15th December 2015

**Re: Objection to State Significant Development Application and Variation of the
Sydney Cove Redevelopment Scheme for the “*Remediation, Renewal and
Adaptive Re-Use of Campbell's Stores*”, The Rocks (SSD 7056)**

We write to object on heritage grounds to the above development application (DA) and request to vary the Sydney Cove Redevelopment Authority Scheme (SCRAS) submitted to the Minister for Planning by Tallawolodah Pty Ltd for proposed works to the Campbell's Stores at The Rocks.

01 WEST ELEVATION
SCALE: 1:200

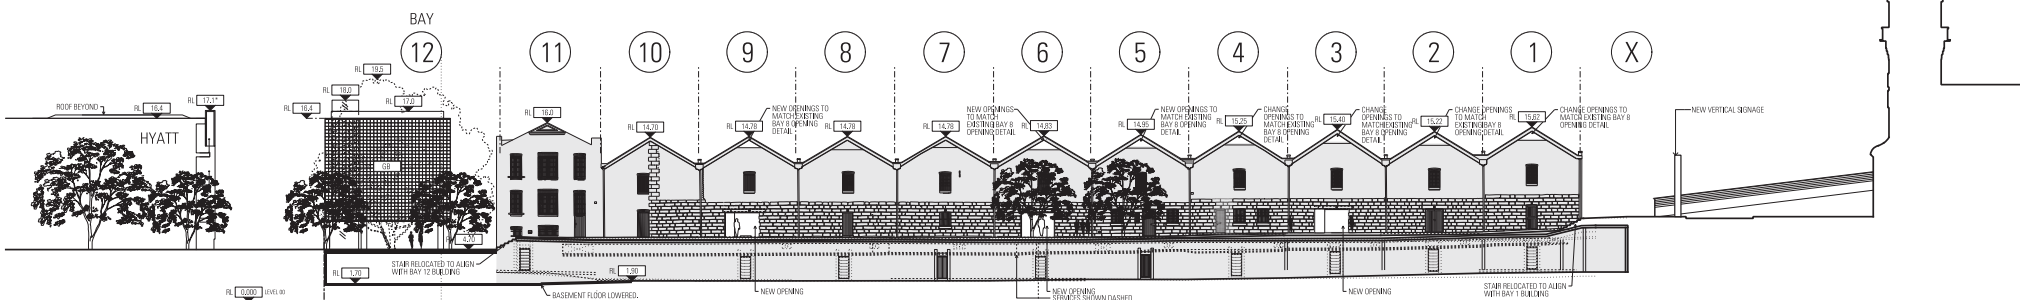
The current proposal involves alterations to three existing openings on the west elevation (Hickson Road façade) and the introduction of new openings to the original south elevation of Bay 1 and the covering over of the ground level openings to the north elevation of Bay 11 (as discussed above). The proposed works to the Hickson Road façade not only will result in widening the existing openings they will also introduce new, concrete entry portals incorporating back-lit signage (Campbell's Stores- Design Statement, JPW, p. 61).

These works should not be approved as they will have a major impact on the significance of the place, dramatically altering the character of the western elevation of the Stores building and introducing non-reversible intrusive elements into a building of 'Exceptional' significance.

As a former, maritime industrial building (warehouse), the west elevation of Campbell's Stores is a simply detailed, functional elevation that still retains its 19th century industrial character. The form, detailing and remnant original features of the west elevation of Campbell's Stores as seen from George Street and Hickson Road provides a clear understanding that this building is a former warehouse building on the foreshores of Sydney Cove.

The Hickson Road façade is the only elevation at the place that is not cluttered or obscured by later additions and features related to the current uses of the place (i.e. restaurant signage, canopy structures, the intrusive pavilion and the southern brick wall). As such, the retention and maintenance of this elevation as a simply detailed, functional elevation with no further alterations or additions is critical to the conservation of the significance of the place as a whole.

The current proposal involves the introduction of new restaurant uses to the Hickson Road façade with the aim of 'activating' the Hickson Road frontage. The proposal involves unsympathetic alterations to existing openings including new concrete entry portals with back-lit signs (as discussed above) and the introduction of chairs and tables, umbrellas and street trees. The end result will be that the Hickson Road frontage will be cluttered, visually obscured and the ability understand the original form and use of this building of 'Exceptional' significance will be further reduced. This component of the proposal for Campbell's Stores has the potential to further erode the character of the place and will negatively impact on the significance of the place as a whole.

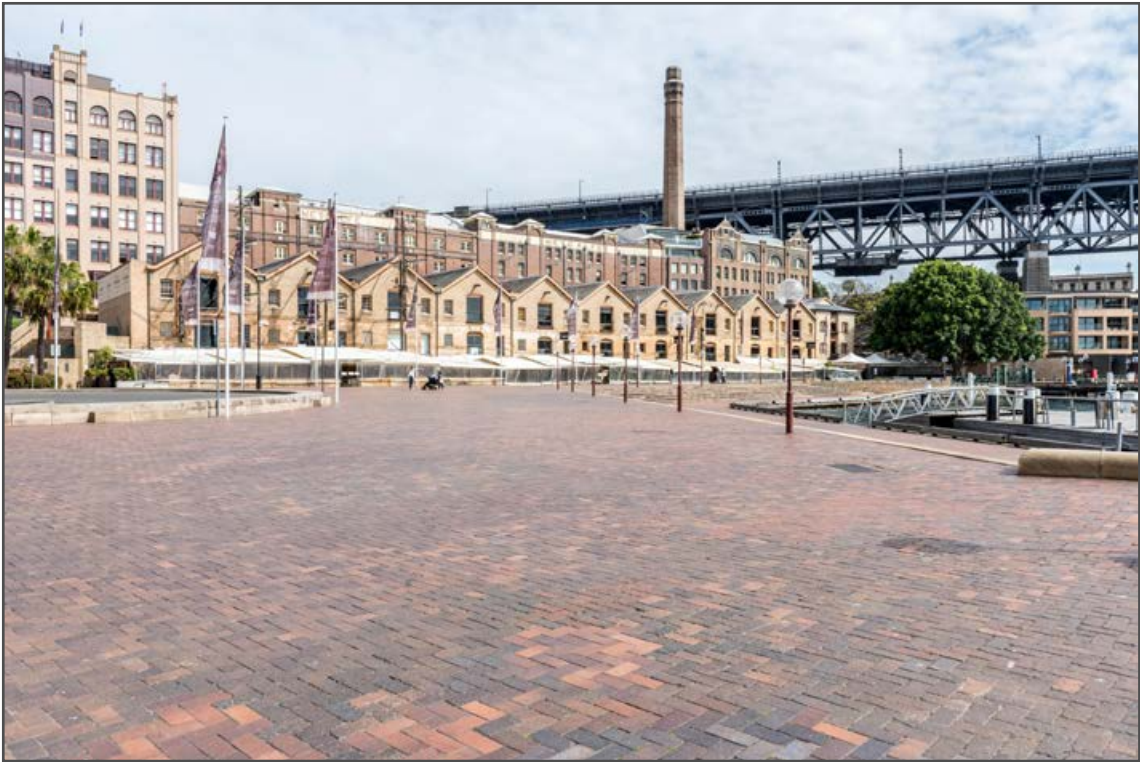
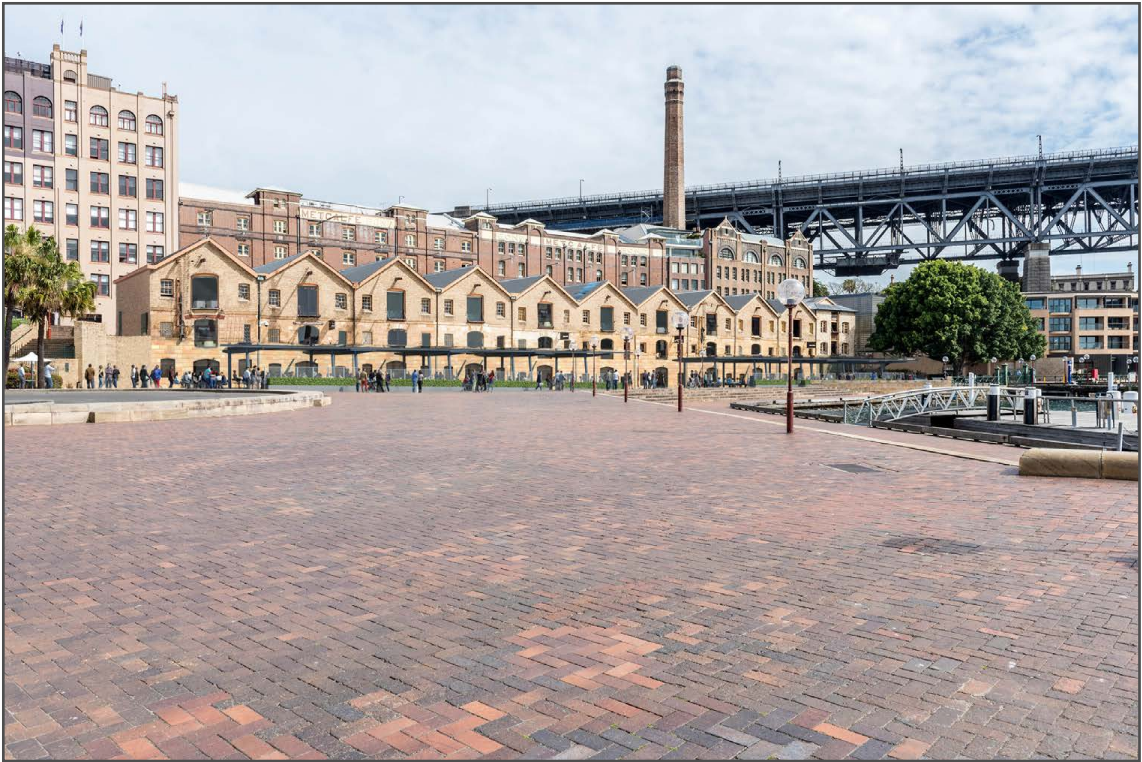
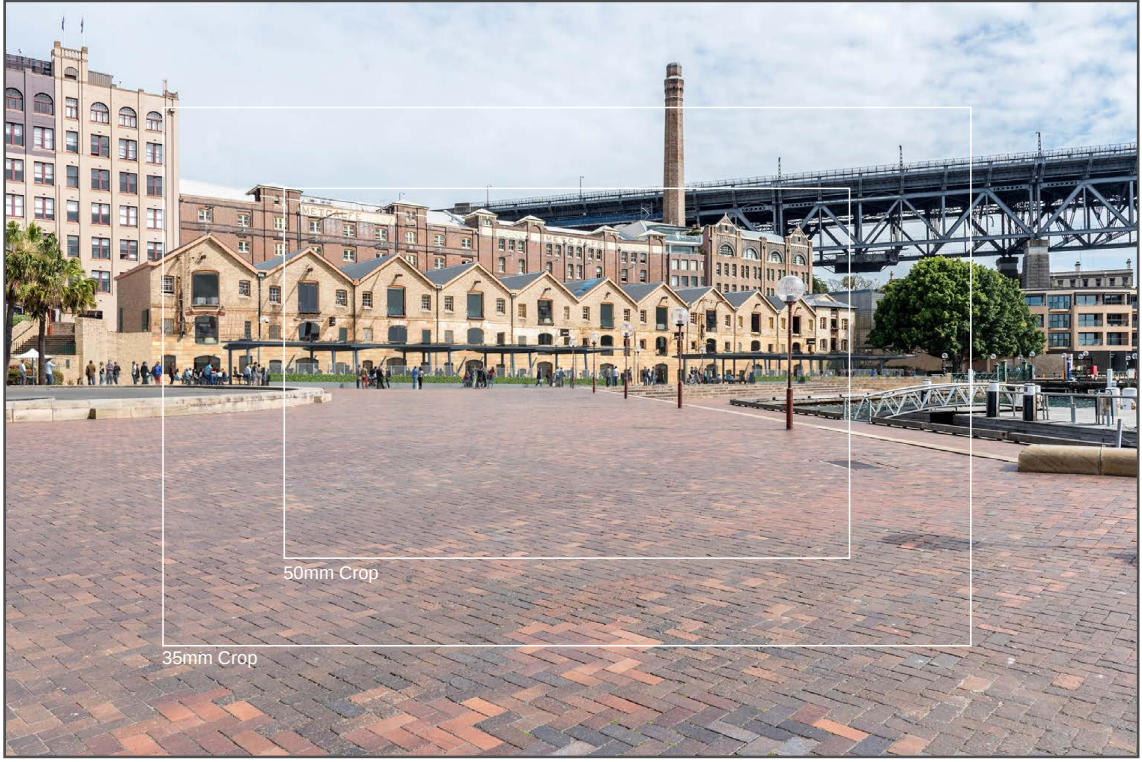
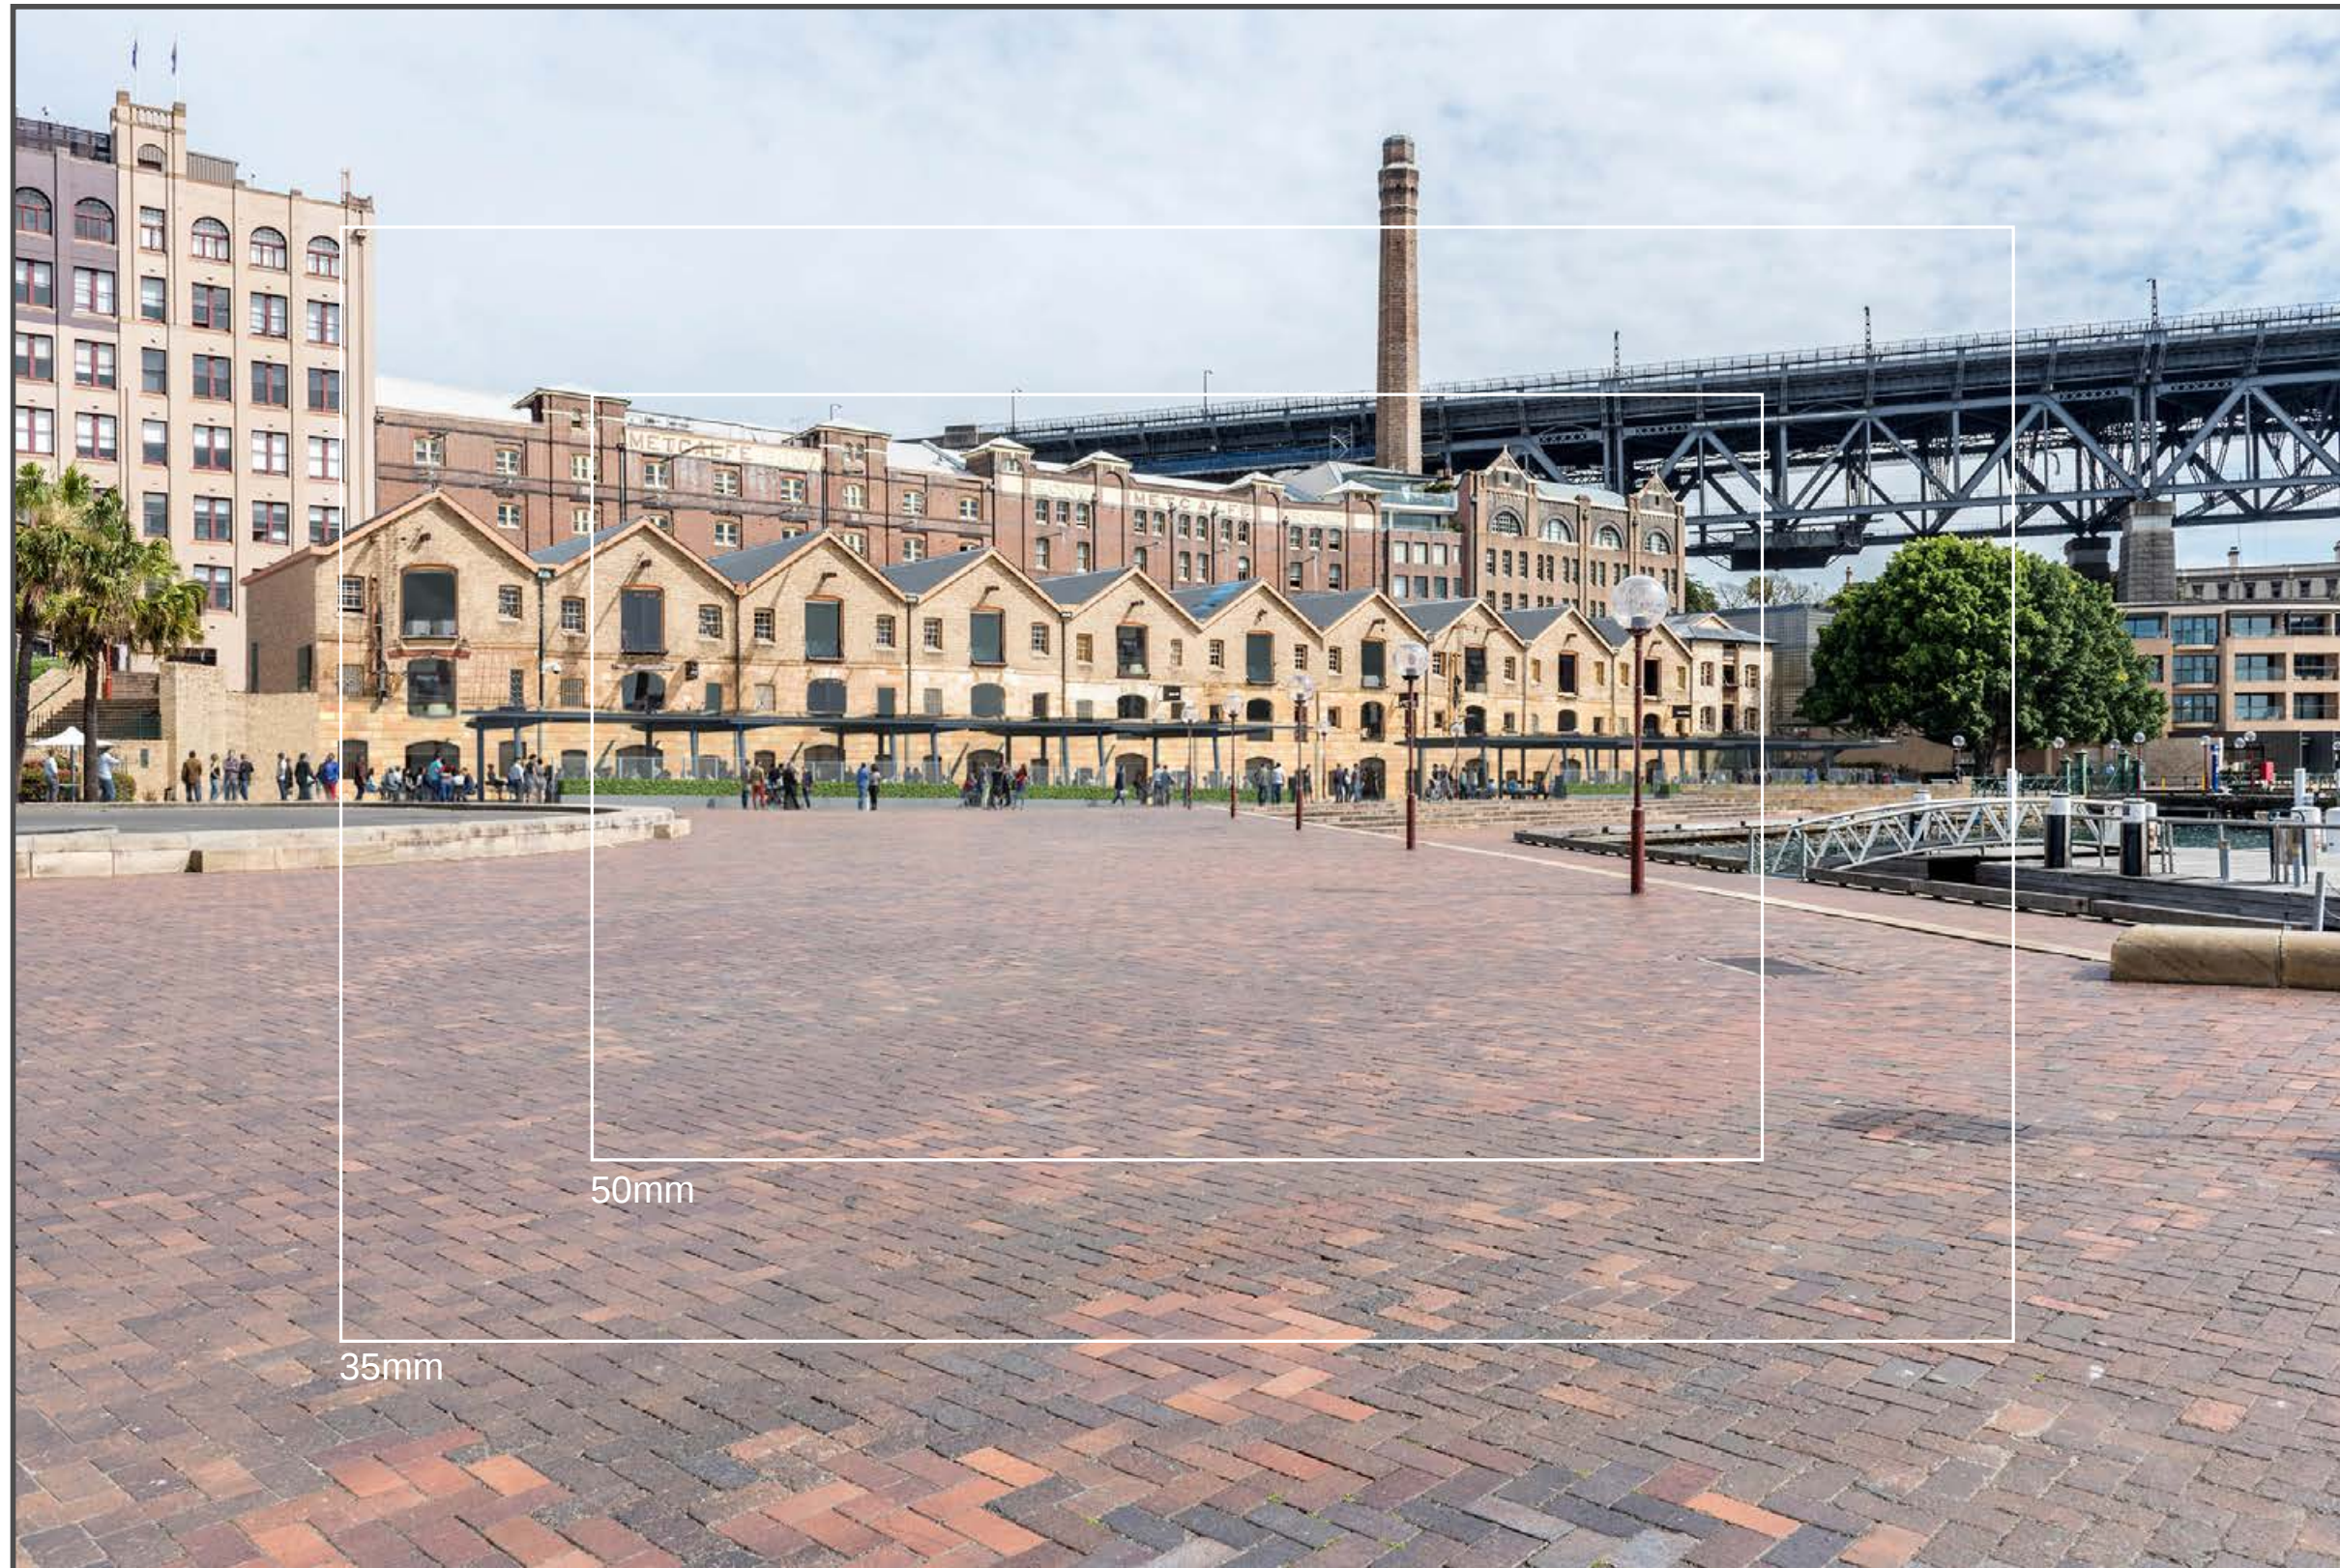
Locating the new glass box in place of the existing intrusive structure to the north of the Stores will obscure views of the northern elevation of Bay 11 and lessen the ability to view Campbell's Stores as a stand-alone warehouse building within its maritime setting, particularly when seen from the north, including from the northern end of Hickson Road and from the pedestrian pathway on the eastern side of the Sydney Harbour Bridge (see Photomontages 6a and 7a).
